Ref: 6/2024/1335/COND
Date: 08/08/2024

HISTORIC BUILDINGS AND CONSERVATION ADVICE

RE: 31A Howardsgate Welwyn Garden City AL8 6AP

This application is for the submission of details pursuant to condition number 2 (Replacement Window Details) and 5 (Details of Bin Storage) on planning permission 6/2022/2632/FULL.

Authentic (2019) Cross Sections

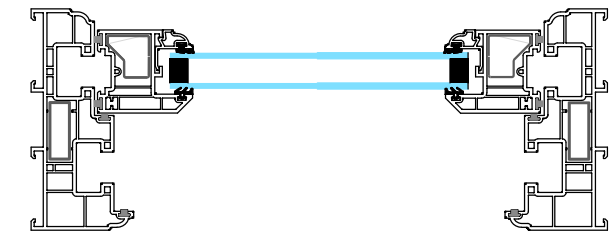
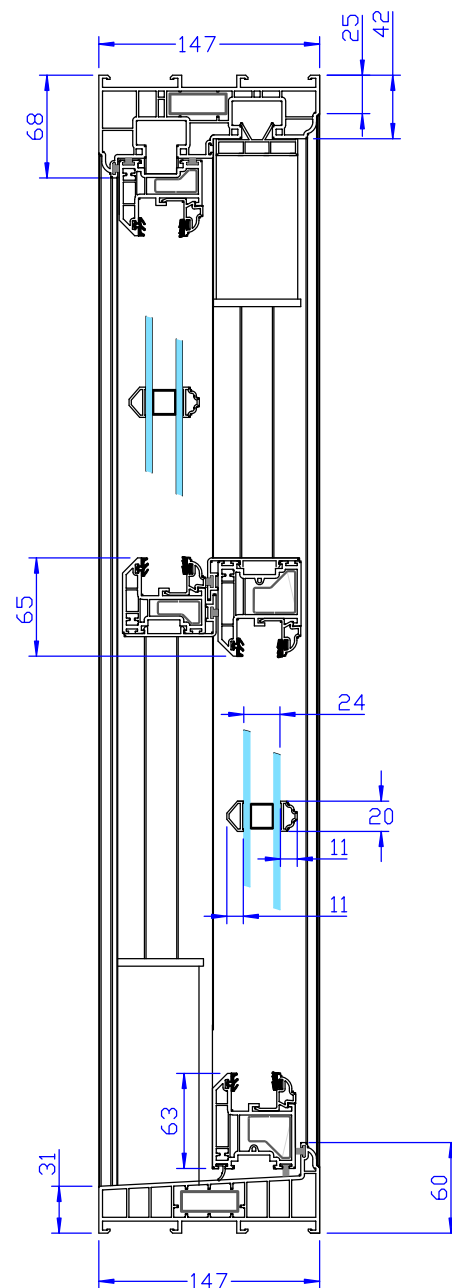
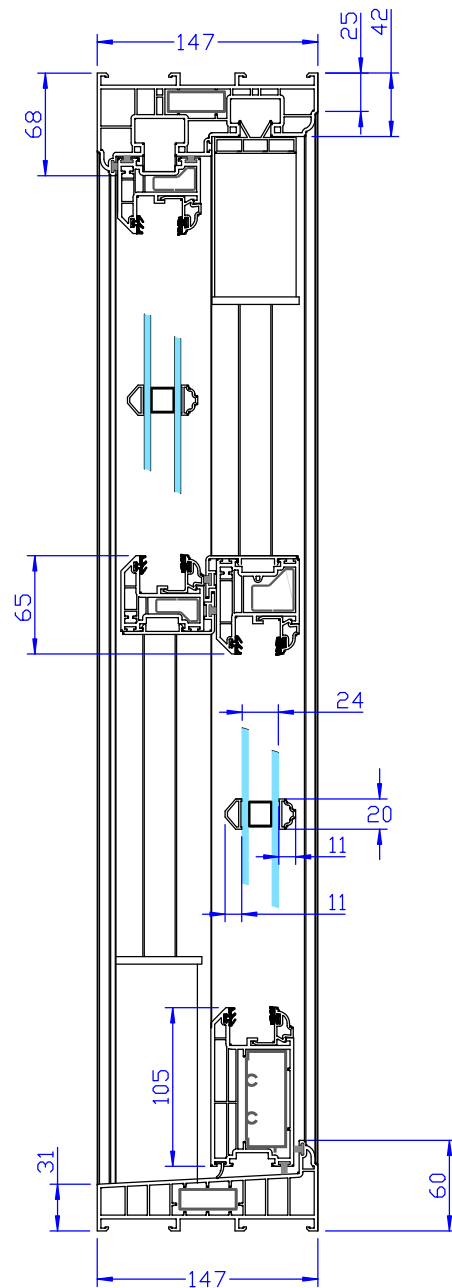
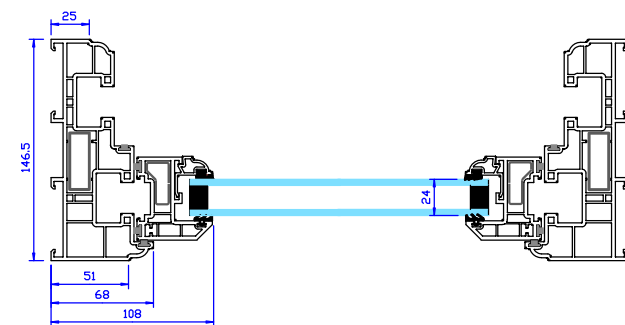
Even if the principle of replacing the existing windows was considered acceptable, the proposed replacement windows would not be considered acceptable from a conservation perspective. The proposed windows would be uPVC and have applied glazing bars. The replacement of traditionally made timber sash windows with modern windows of a non-traditional material and detailing would

be inappropriate and unsympathetic, detracting from the architectural interest of Number 31A and the contribution it makes to the Conservation Area.
